# CITY OF PORTLAND BUILDING PERMIT

**PERMIT ID:** 2013-00256

68 COMMERCIAL ST - MAINE WHARF - end  
of Building A)

has permission to **Repair part of existing Building 'A' (interior work) - 40' x 39' area - use is undetermined at this point - need to apply for tenant fit up permit when occupied** provided that the person or persons, firm or corporation accepting this permit shall comply with all of the provisions of the Statues of Maine and of the Ordinances of the City of Portland regulating the construction, maintenance and use of the buildings and structures, and of the application on file in the department.

A1.01

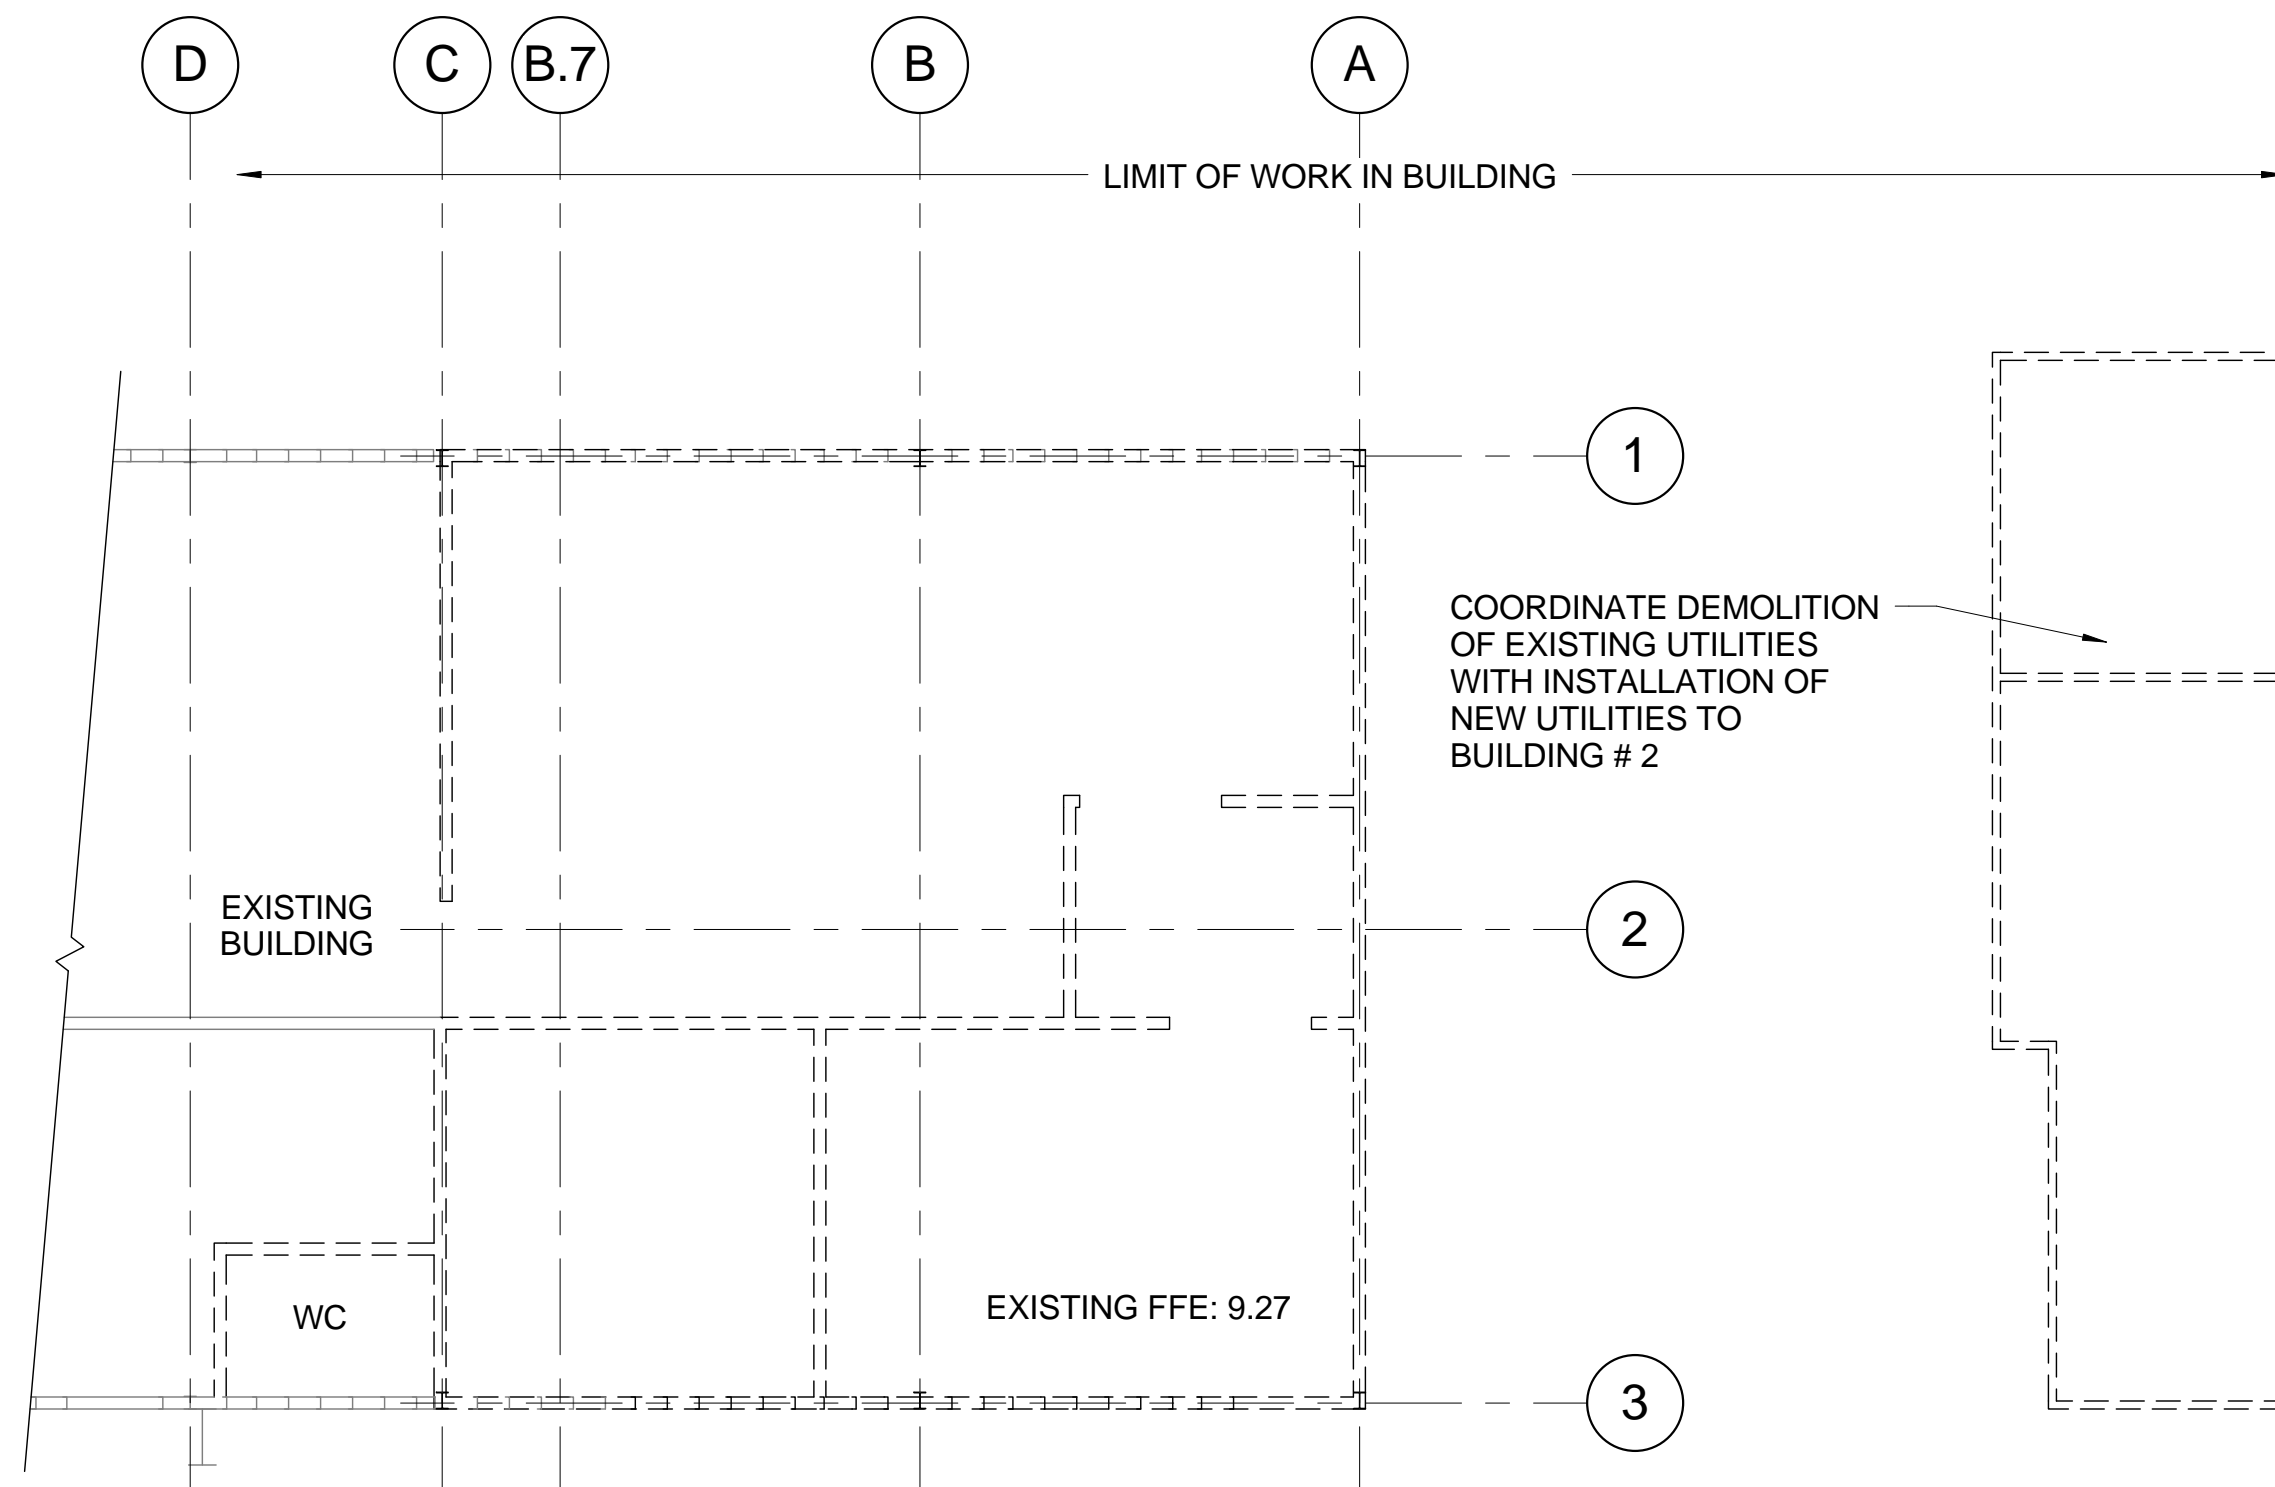
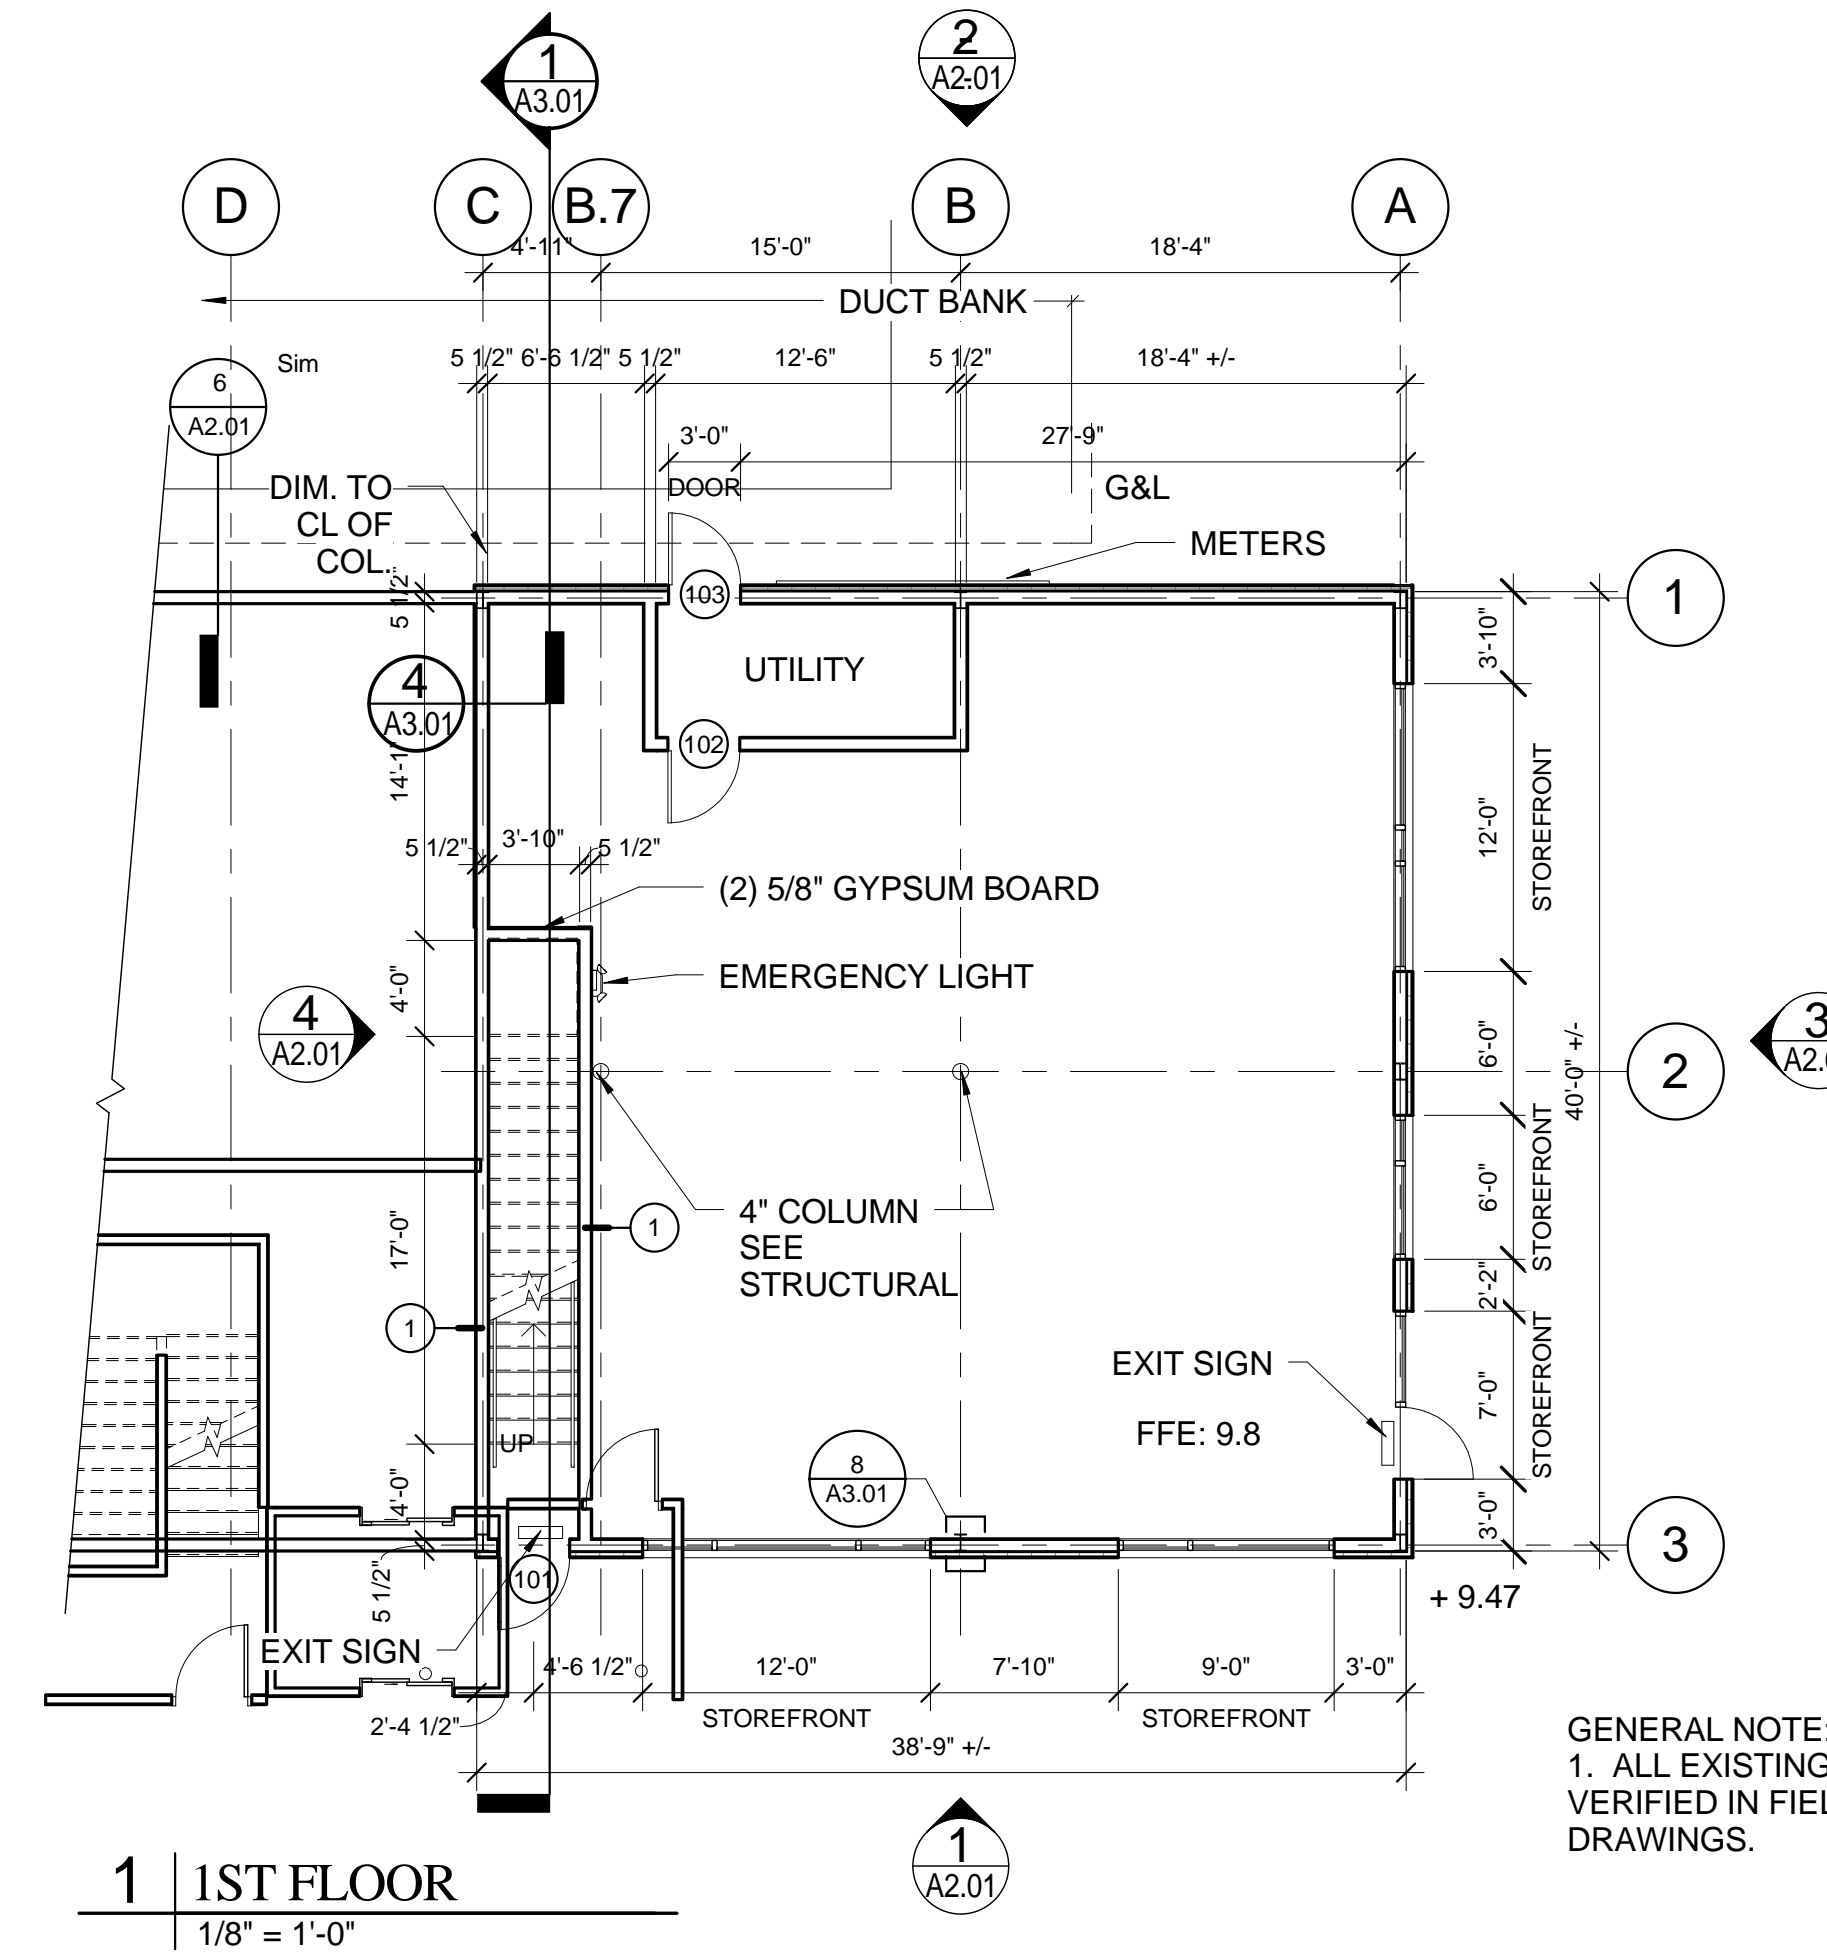
Requiring Code Analysis from the design professional in responsible charge, and clarification on of elevations, separations, and uses.
